April 10, 1998

**RE: Grading and Drainage Plan for Cordova Residence, Lot 27, Block 12, Tract 1, Unit 3, NAA, (B19/D11) Engineer's Stamp Dated 3/27/98.**

CORDOVA RESIDENCE
GRADING & DRAINAGE PLAN

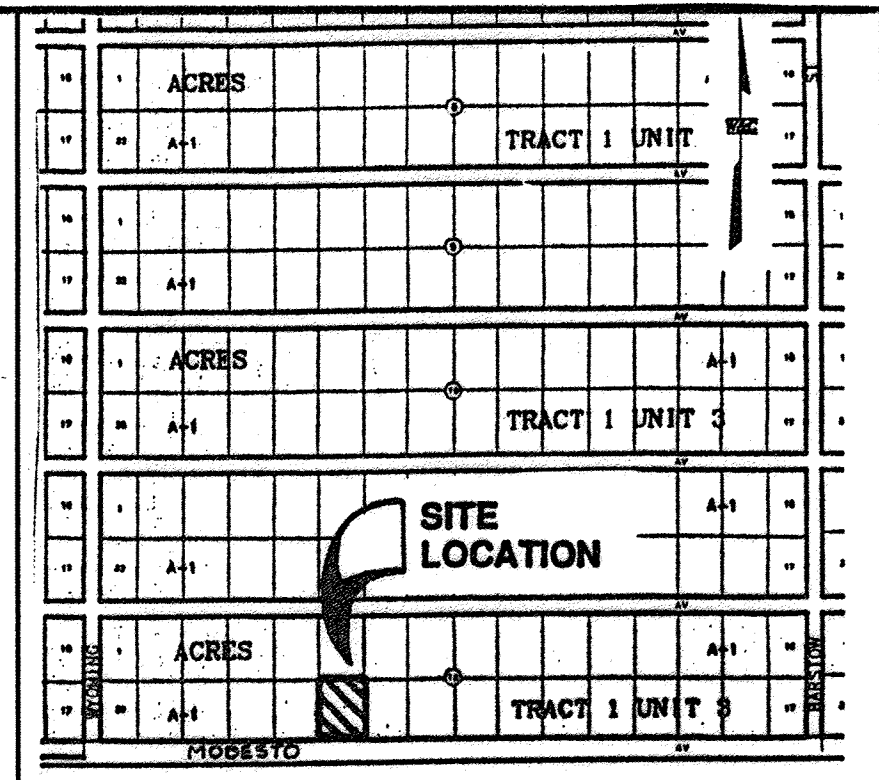
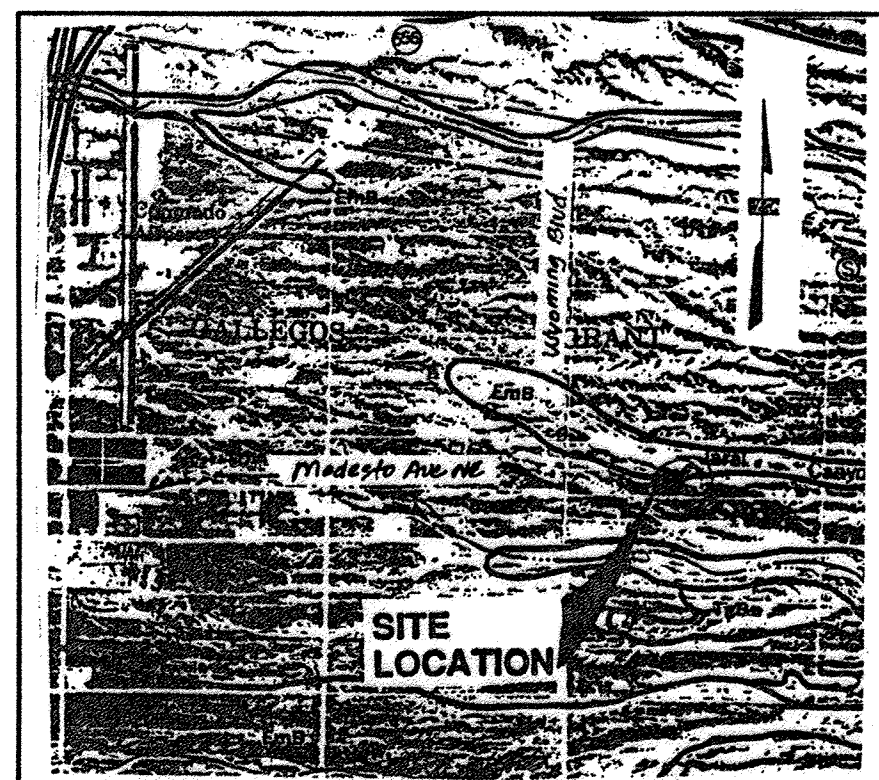
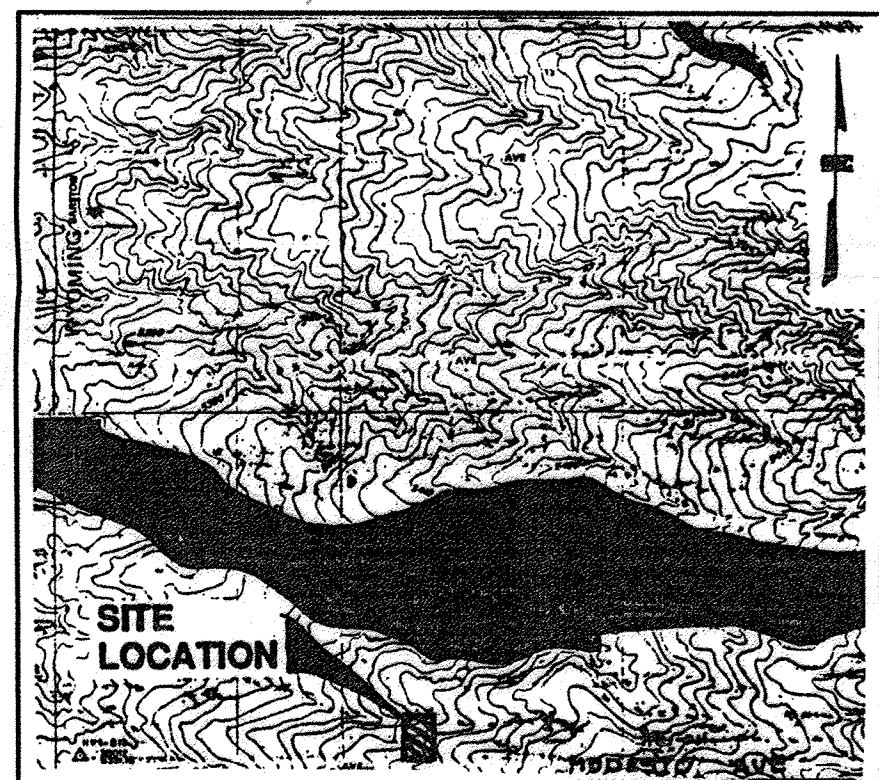
As you are aware, the Engineer's Certification, including the certification of the rip-rap, is required prior to Certificate of Occupancy release for this residence. On the Certification, please clean up the plan, identifying the basin area and runoff amount for Basins 101 and 102.
